From: Bloomer, David <David.Bloomer@lancashire.gov.uk>
Sent: 02 August 2019 10:59
To: Rebecca Bowers
Cc: LHS Customer Service; planning
Subject: App3/2019/0615 Craven District Boundary sign.

Project: Craven Boundary Signs
Title: Proposed Sign Design at Nappa A682
Scale: 1:10 @A3
Date: 01/07/2019
Drawn: RS

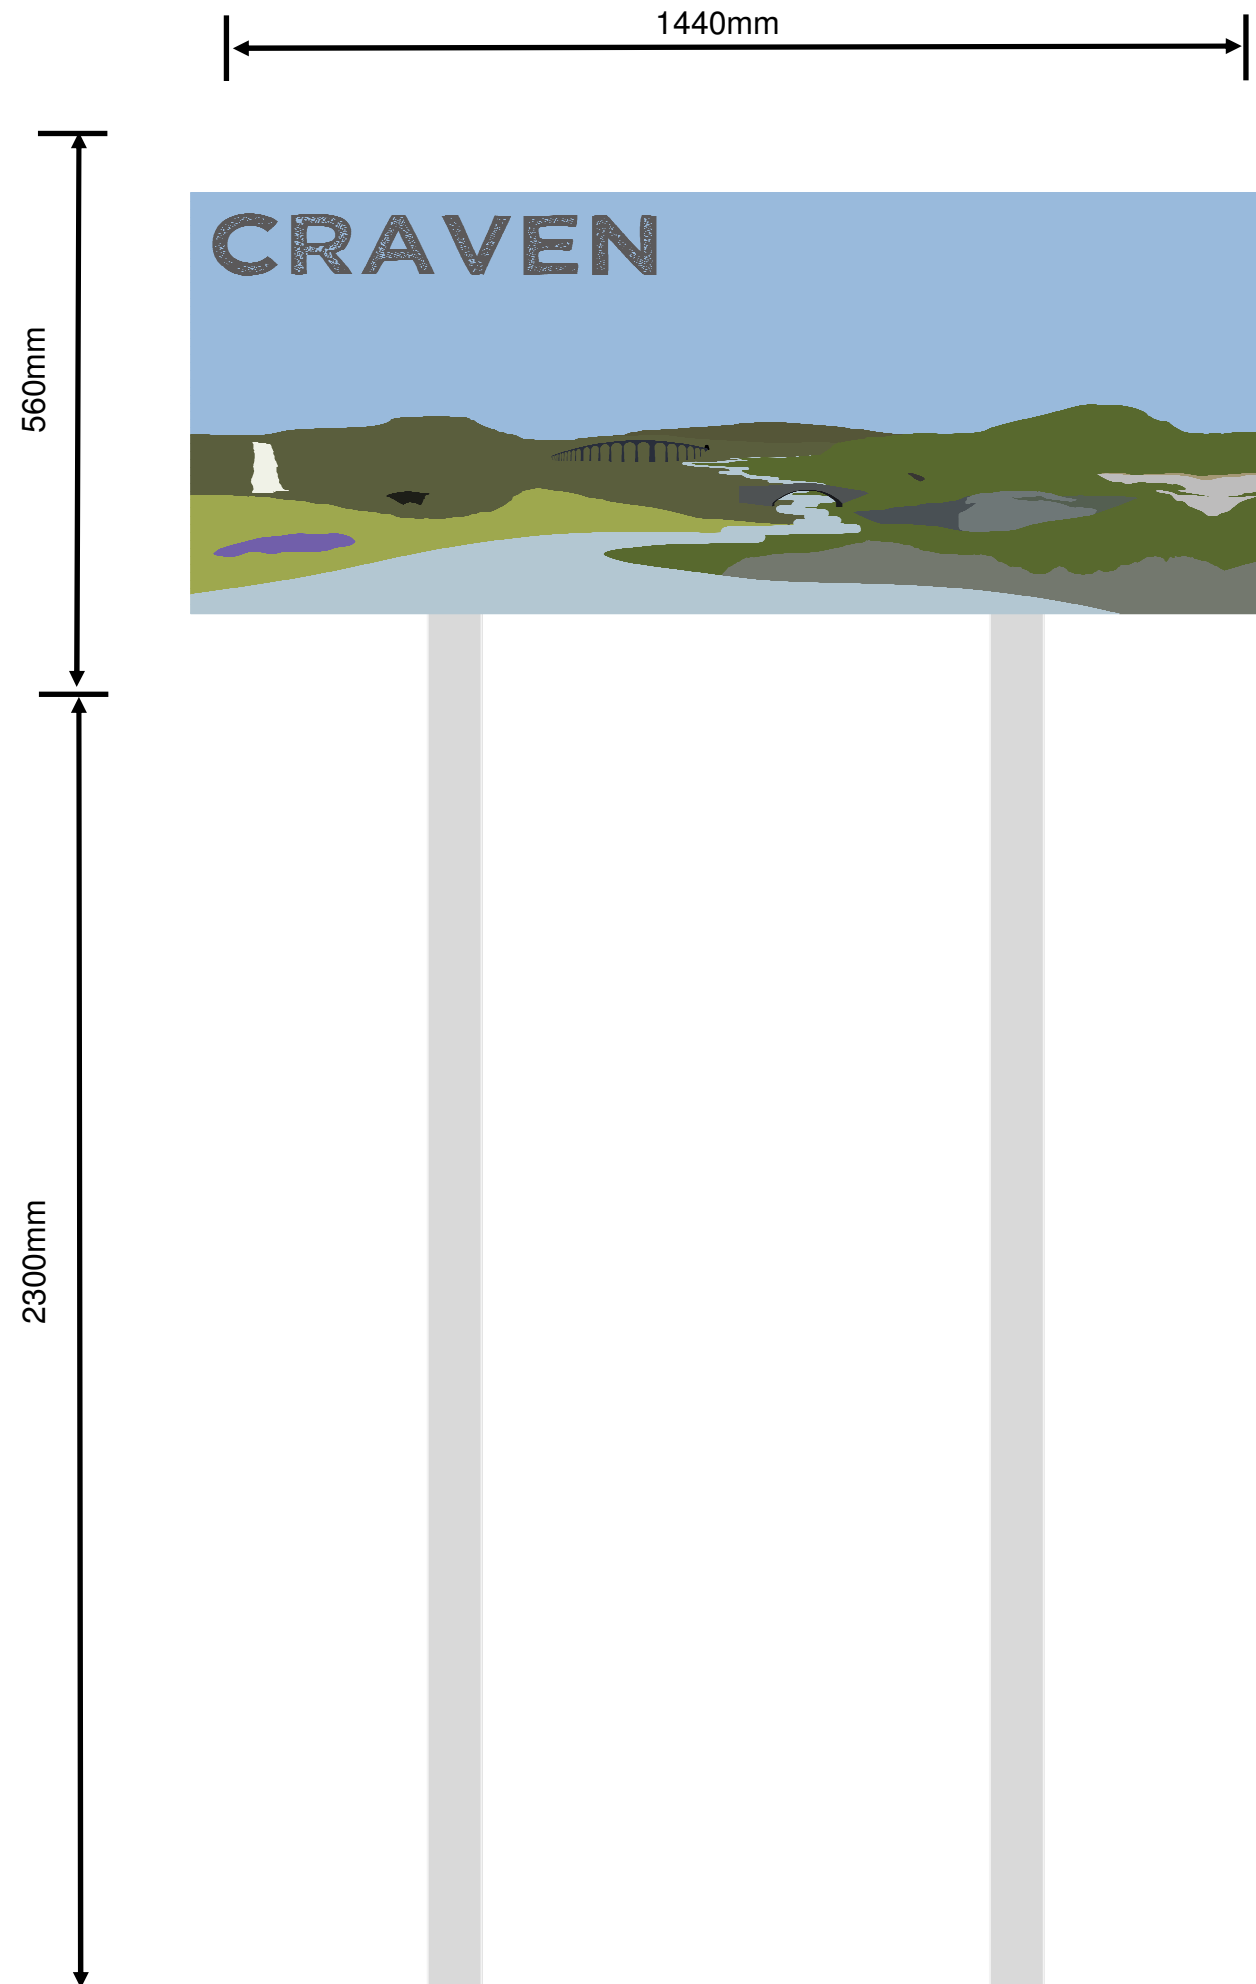
The proposal suggests that the sign is to be mounted below an existing sign and utilising an additional second post. Whilst I would raise no objection to the proposal in principle, I need to be certain that the new sign assembly does not pose any highway safety concerns. In view of the dimensions of the proposed sign and the limited verge width I would need to know where the additional post is to be erected (within the highway verge or over the wall) and that a minimum clearance of 450mm is maintained between the sign assembly and the carriageway.
